SUPPLEMENTAL/AMENDED INFORMATION
TO DRAINAGE REPORT
DATED APRIL 23, 2013

INLAND KENWORTH
Fortuna Rd West of 76th Street NW

RESPONSES OF CITY OF ALBUQUERQUE COMMENTS:

**Re: Inland Kenworth, Fortuna Road, Drainage Report and Conceptual Grading
and Drainage Plan**

Date:	6/18/13
Drawn By:	DH
Job:	KENWORTH
Job No.:	L-800 ABC-
Sheet:	CG-102

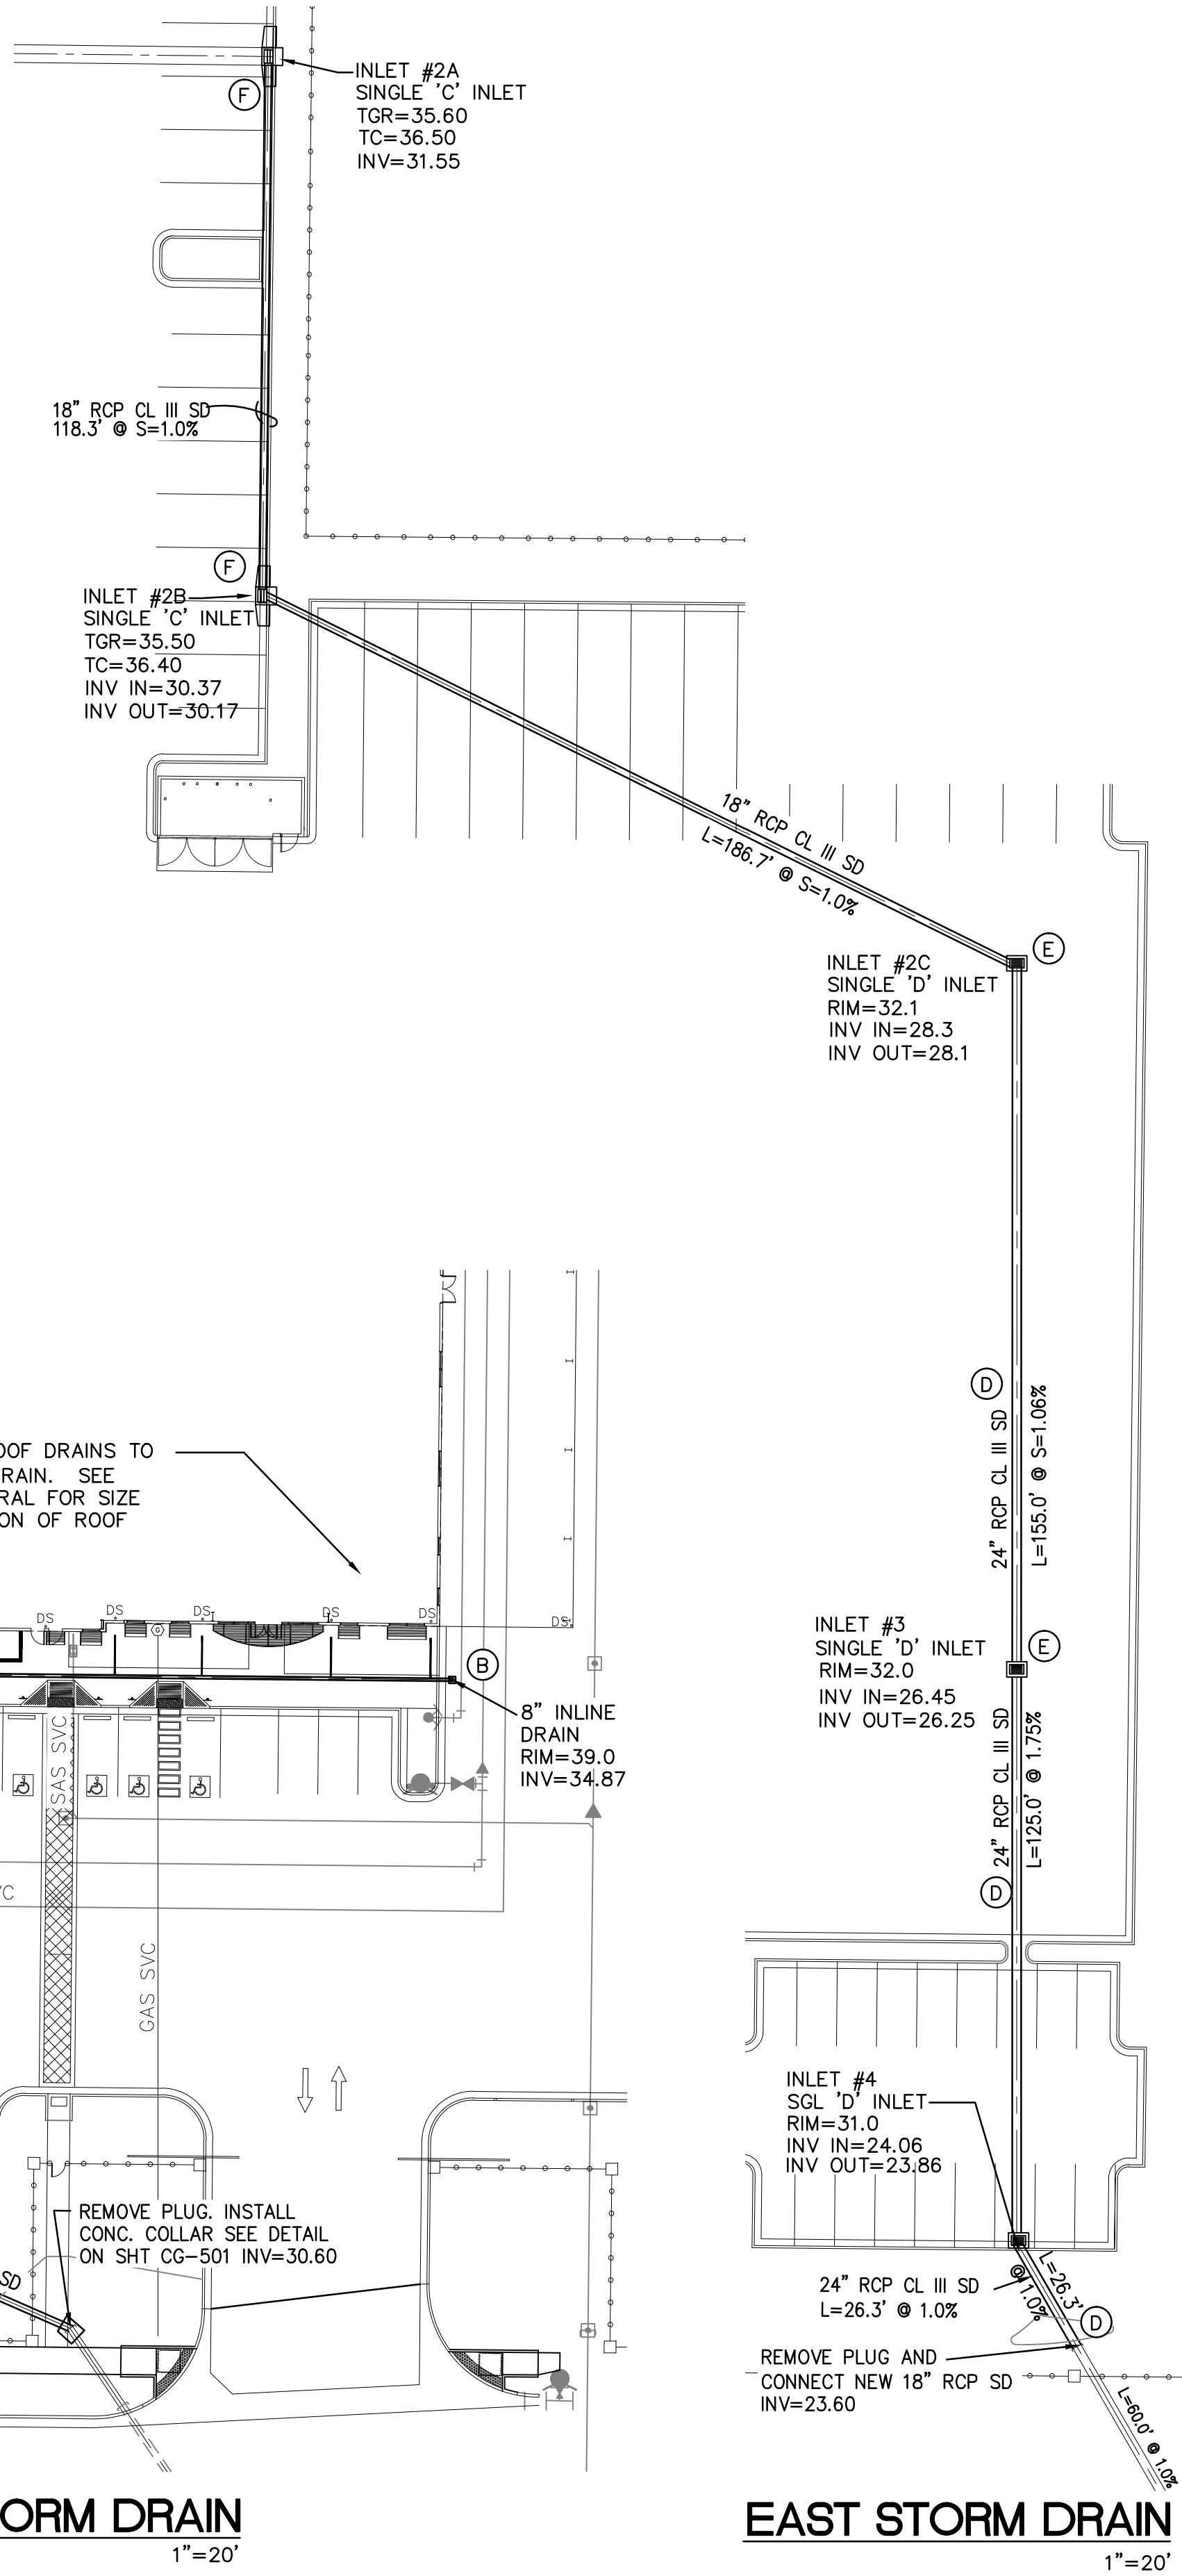
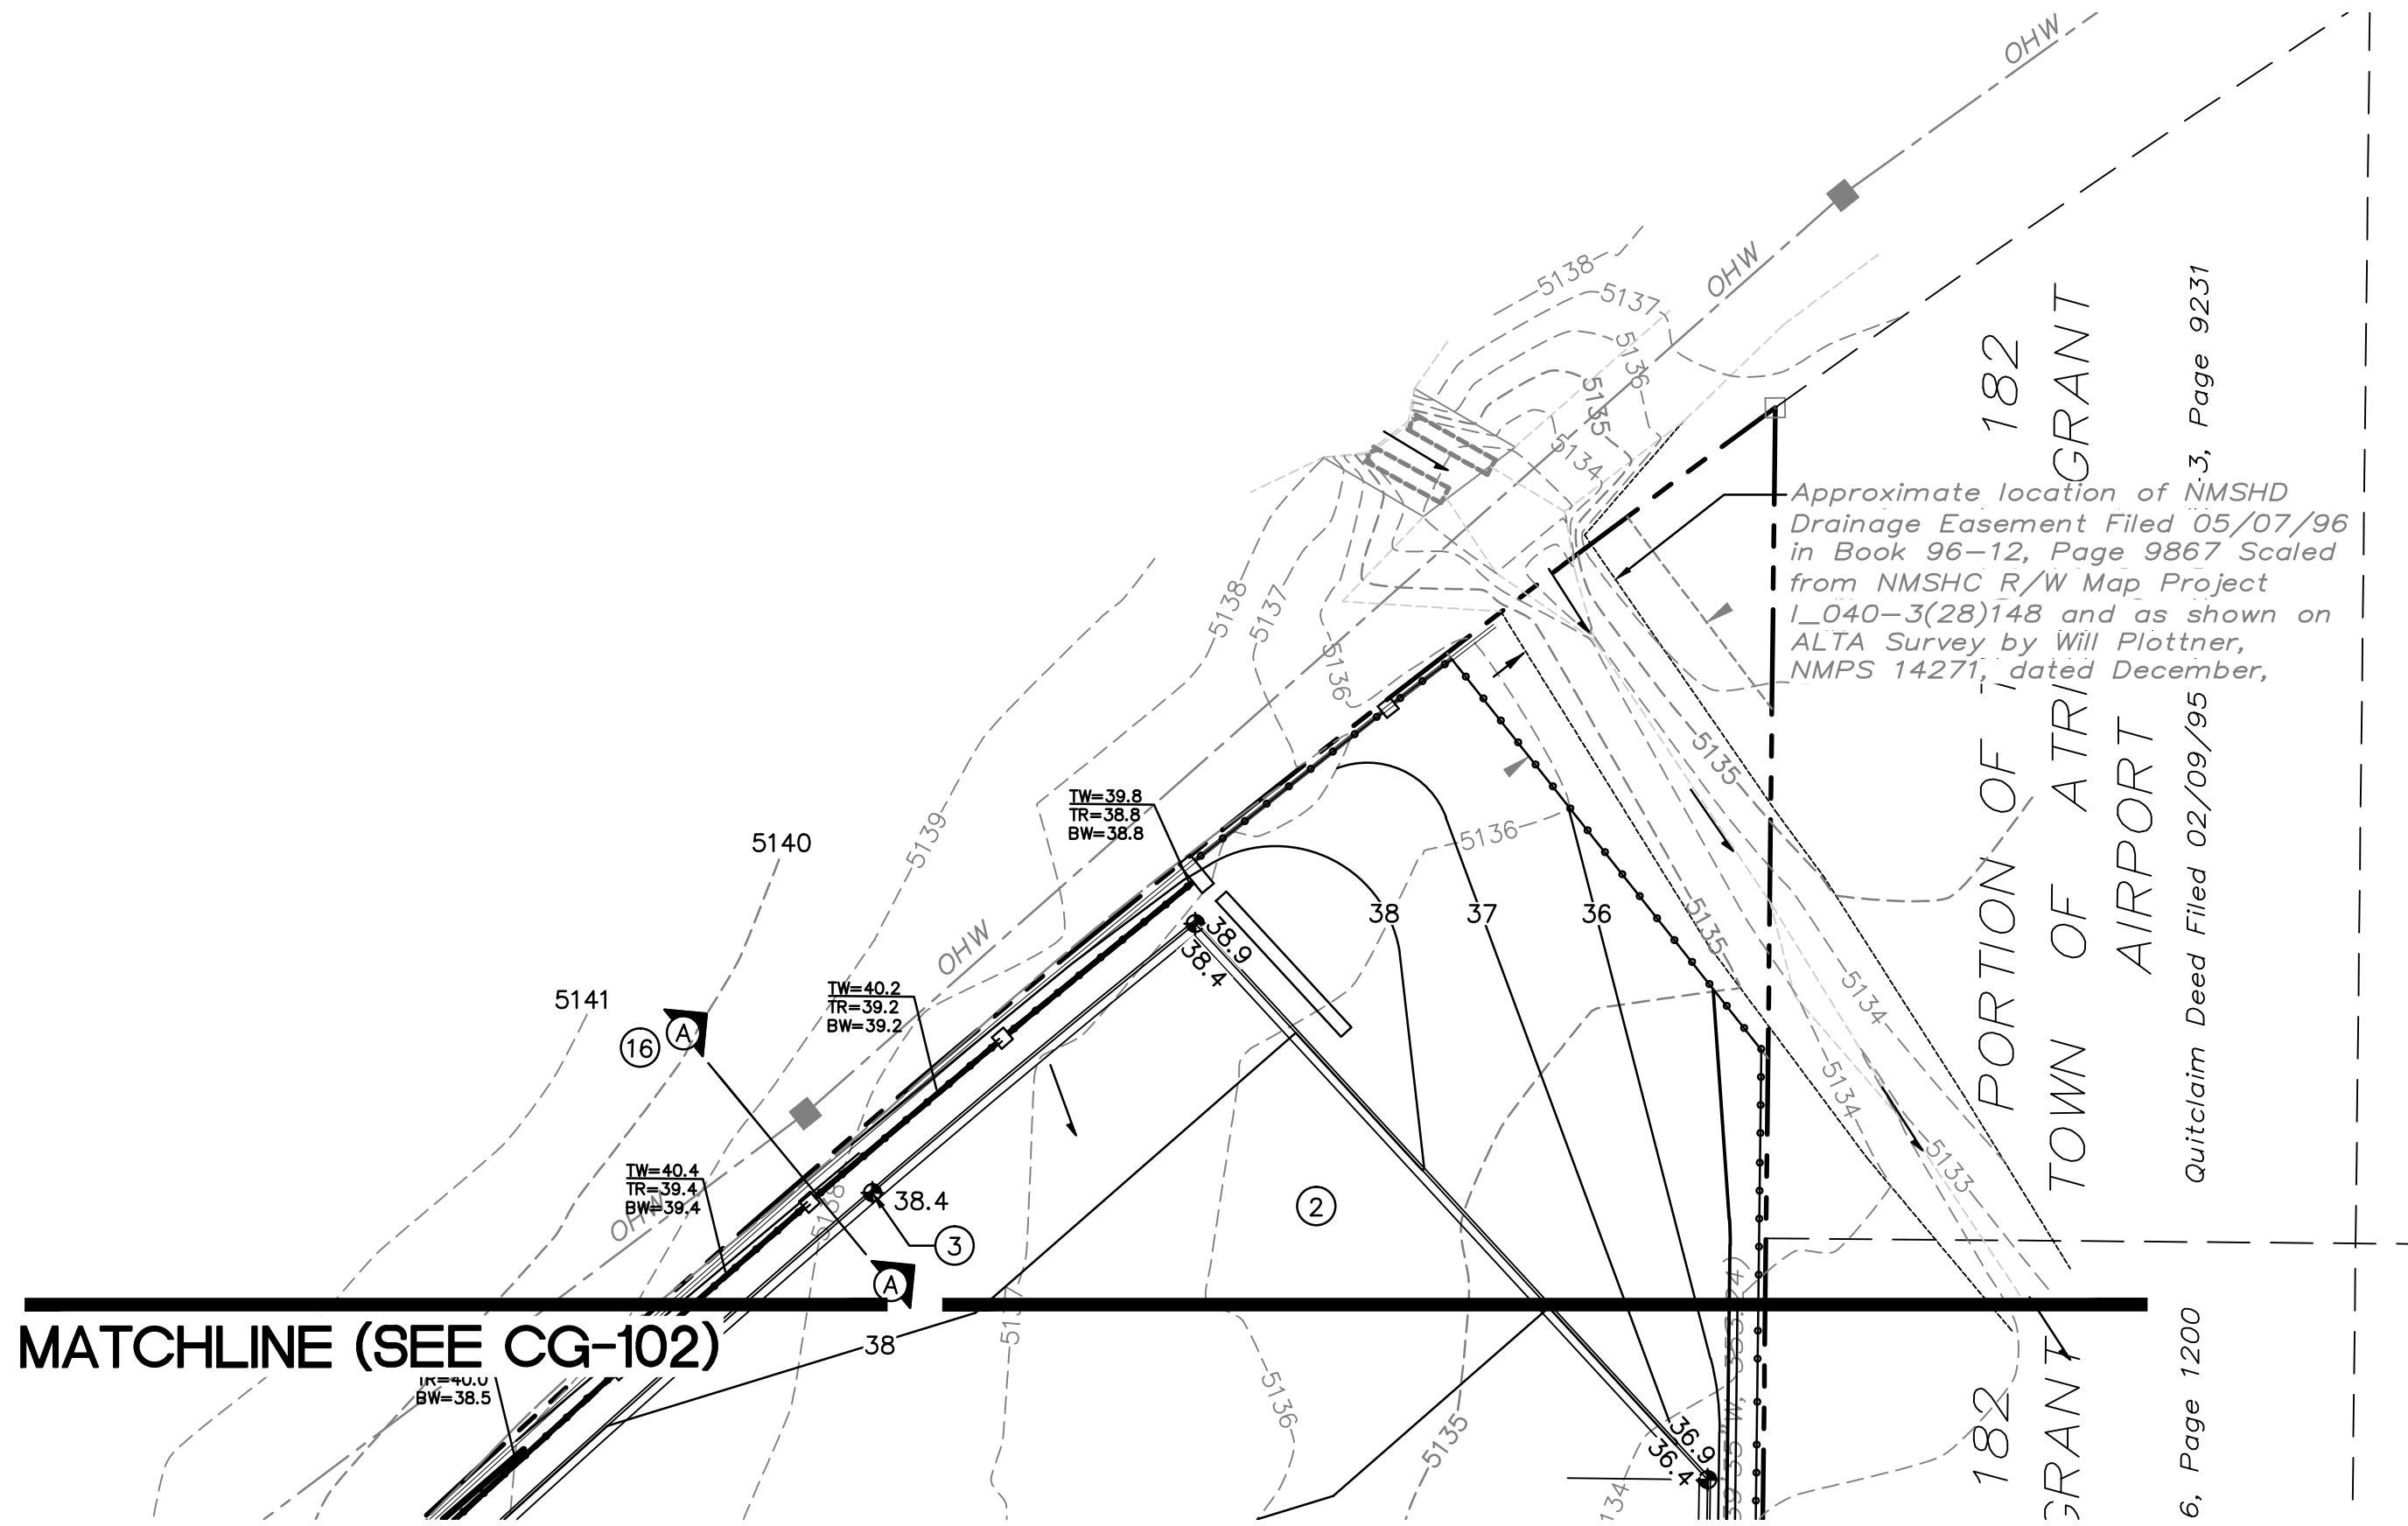
- 1) Two sheets are numbered CG-101.
- 2) Please include proposed flow lines and back of sidewalk elevations along Fortuna Rd.
- 3) Provide inlet capacity calculations. Assume 50% clogging factor in your calculations.
- 4) Add all the curb opening sizes on the plans.
- 5) Provide calculations for the channel located east side of Basin 2. Include a section for the channel on the plan. Can the runoff overflow the channel when making a 90 degree turn?
- 6) Add all the storm drain pipe sizes to the plan.
- 7) The runoff appears to be block at the north east corner of the property where the offsite runoff enters the site.
- 8) Based on the documents provided the allowable discharge is 3.76 cfs/ac. Therefore, the total discharge is (8.86 ac x 3.76 cfs/ac) 33.31 cfs, and the plan shows an allowable discharge of 34.60 cfs. Please clarify.

- 1) A new grading plan is attached—Sheets CG-101, CG-102, CG-103 and CG-105.
- 2) Flowline and back of sidewalk grades along Fortuna are included.
- 3) Capacity calculations for inlets are included.
- 4) Curb opening sizes are included on plan.
- 5) Channel has been eliminated and replaced with 2-Type C inlets and storm drain.
